## Attachment A

### Response to Agency Submissions

Penrith City Council

Table 1: Response to Penrith City Council's comments

## Landscape Sketch Plan - Lot 4E

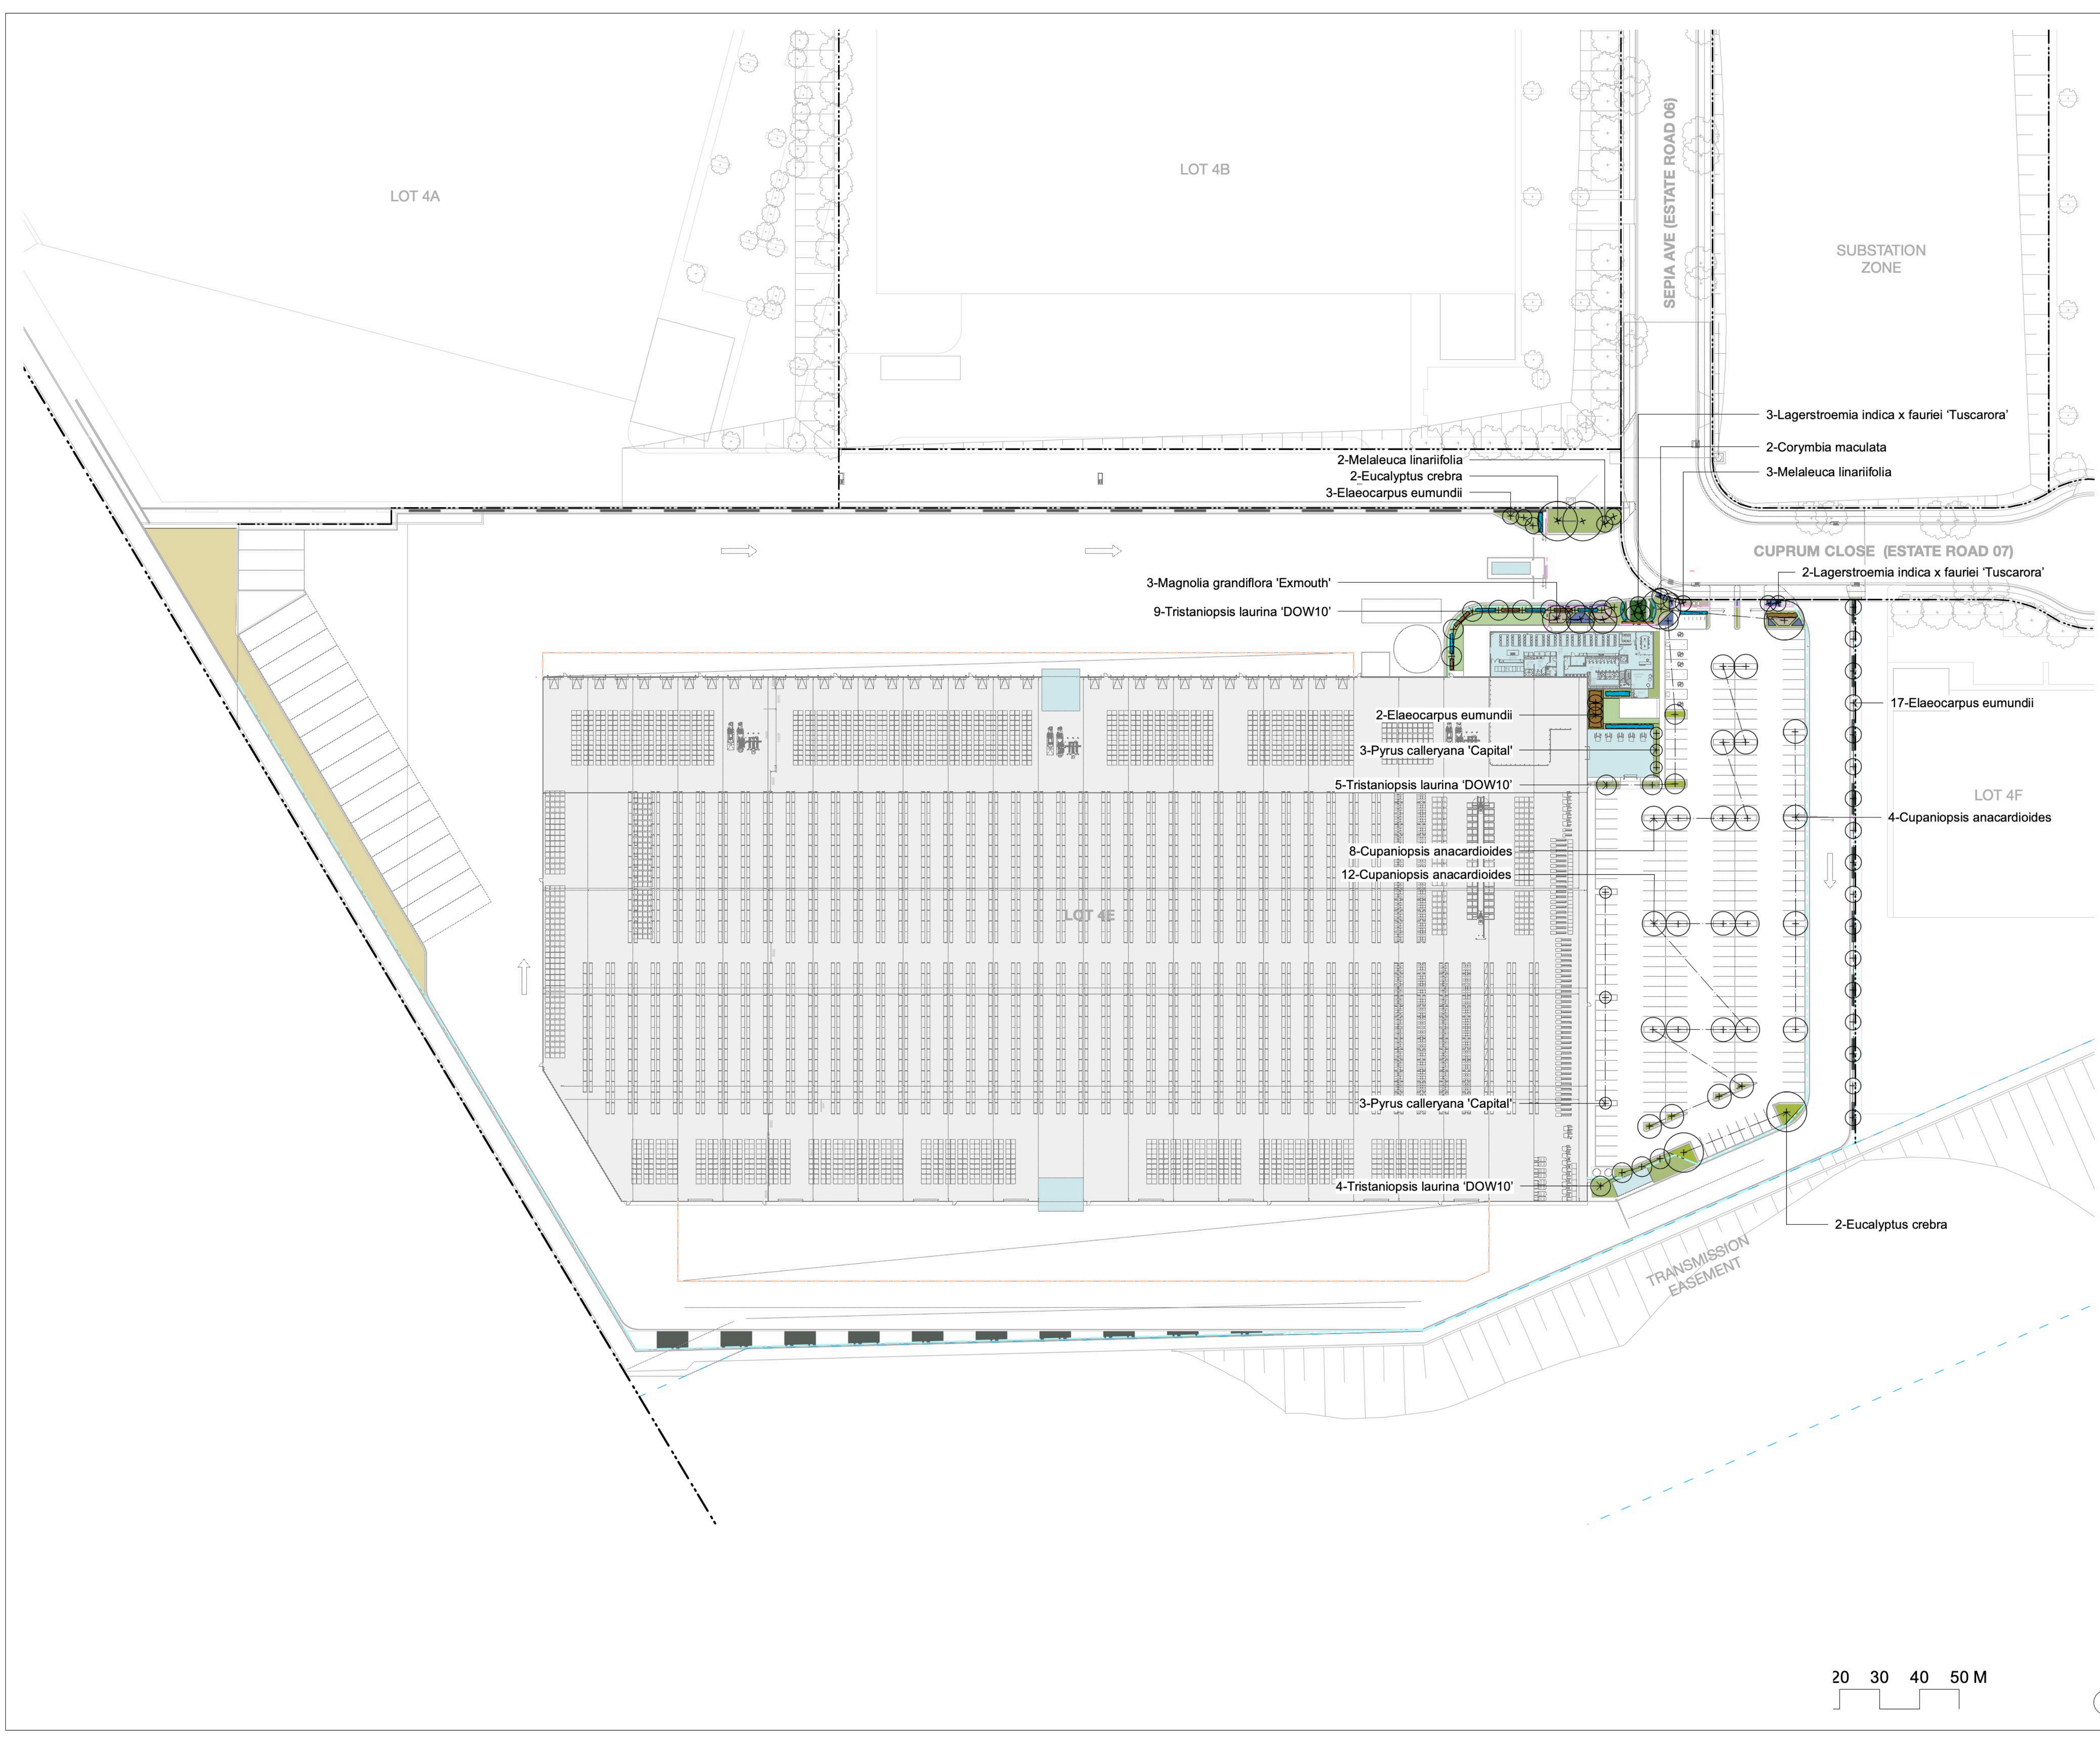
| PCC Issue  | Comment/Response   |
|--|--|
| Insufficient canopy plantings in front setback of entry areas is evident and this should be reconsidered.  | <p>Consideration has been given to the extent of canopy plantings in front setback. Additional canopy plantings are proposed at the setback and office frontage where available (see updated Landscape Plans in Attachment B).</p> <p>Given number of access points provided within close proximity along the Estate Road, plantings have been designed to ensure acceptable sightlines.</p> |
| <p><u>Carpark Design</u></p> <p>It is considered there is insufficient canopy and cooling of the carpark. The planting proposed is not 'significant' in terms of tree canopy, as per the statement. Larger trees with broader canopies are appropriate and will provide greater cooling of pavement areas, meeting Council's Cooling the City and NSW Greener Places Guide objectives and targets.</p> | <p>Constructed tree pits are provided under the hardstand to provide larger plantings throughout the car parking areas.</p>  |
| Mounding with shrub planting should be considered to contribute to the screening of parking areas from the public domain.  | <p>The Landscape Plans have been updated to soften the carpark entry.</p> <p>Due to the operational nature of the development, shrub planting on mounds is not preferred as it requires significant upkeep.</p>  |

01 Entry marker  
Detailed Elevation - Scale 1:50 @ A1

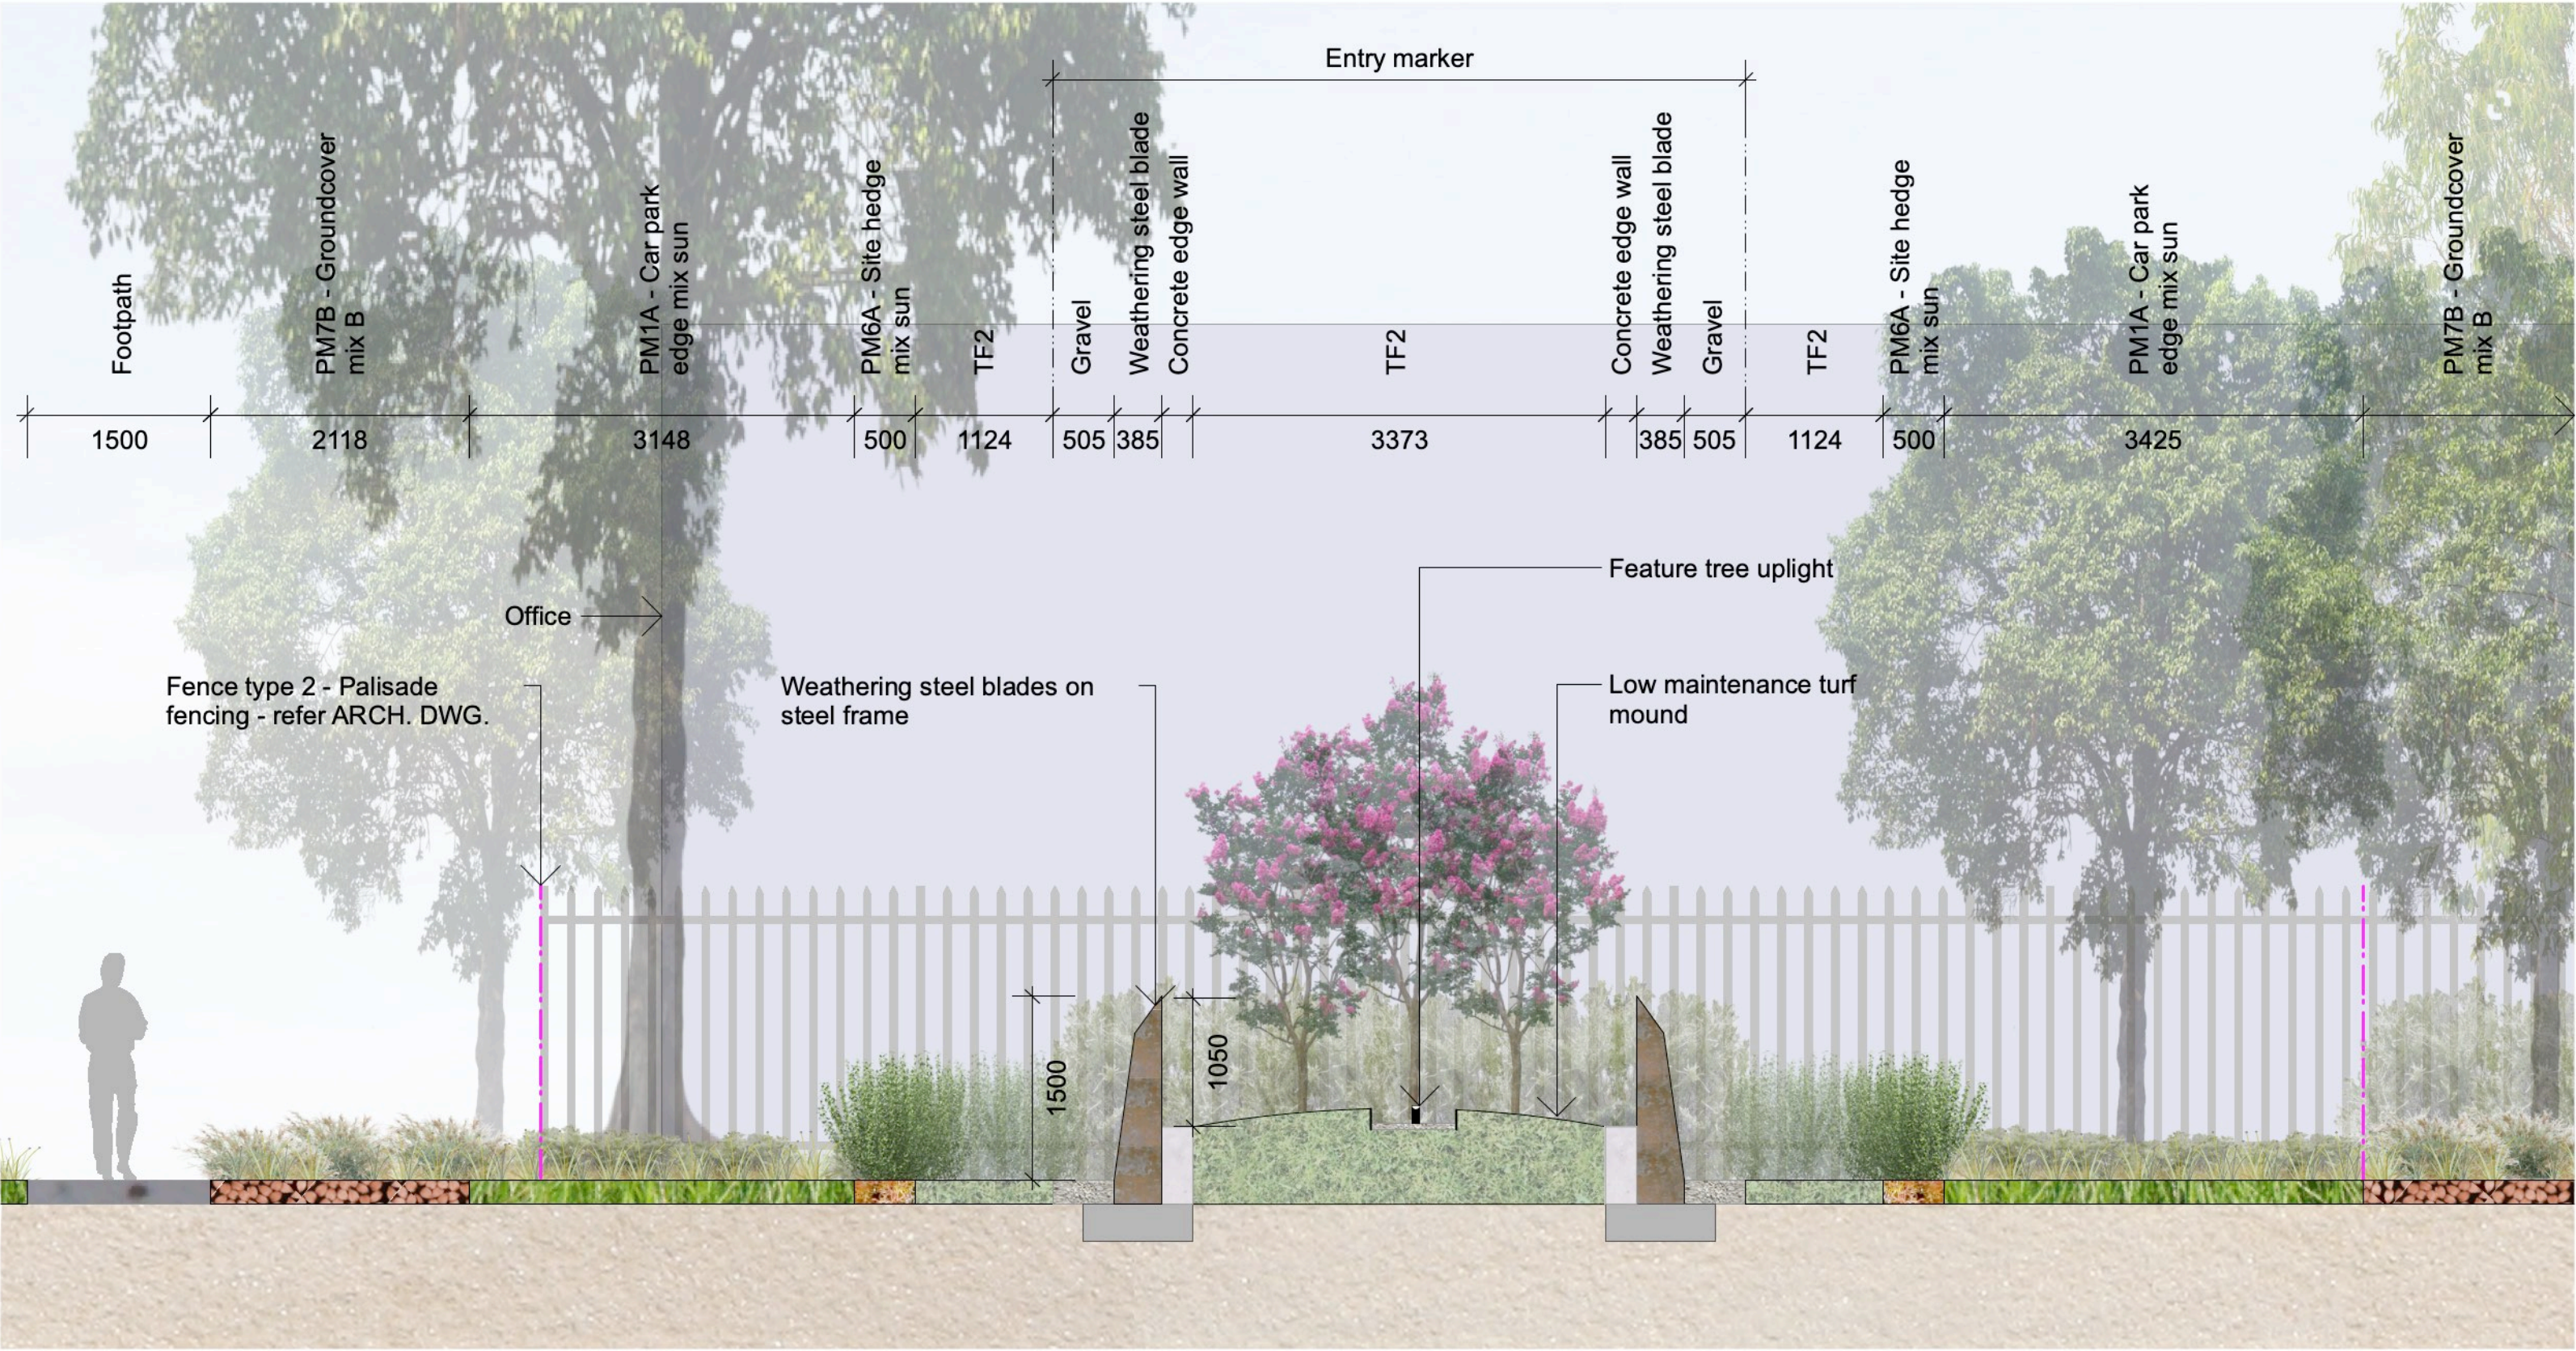
| PCC Issue  | Comment/Response   |
|--|--|
| <p>Entry marker detail has been proposed at other developments. For wayfinding and placemaking, a different maker design should be provided. This may be designed with consideration of proposed signage, and vice versa. Entry markers should feature a tree of significant scale, as well as interest, noting that a significantly larger tree than the proposed Crepe Myrtle is recommended.</p>                              | <p>Given the reduced frontage to the street, providing significant entry marker detail is limited.</p> <p>Updated Landscape Plans are provided in Attachment B.</p> <p>Utilising crepe myrtle for entry marker breaks up the use of larger trees in other parts of the development and acts as a wayfinding identifier for entries to each warehouse building.</p>   |
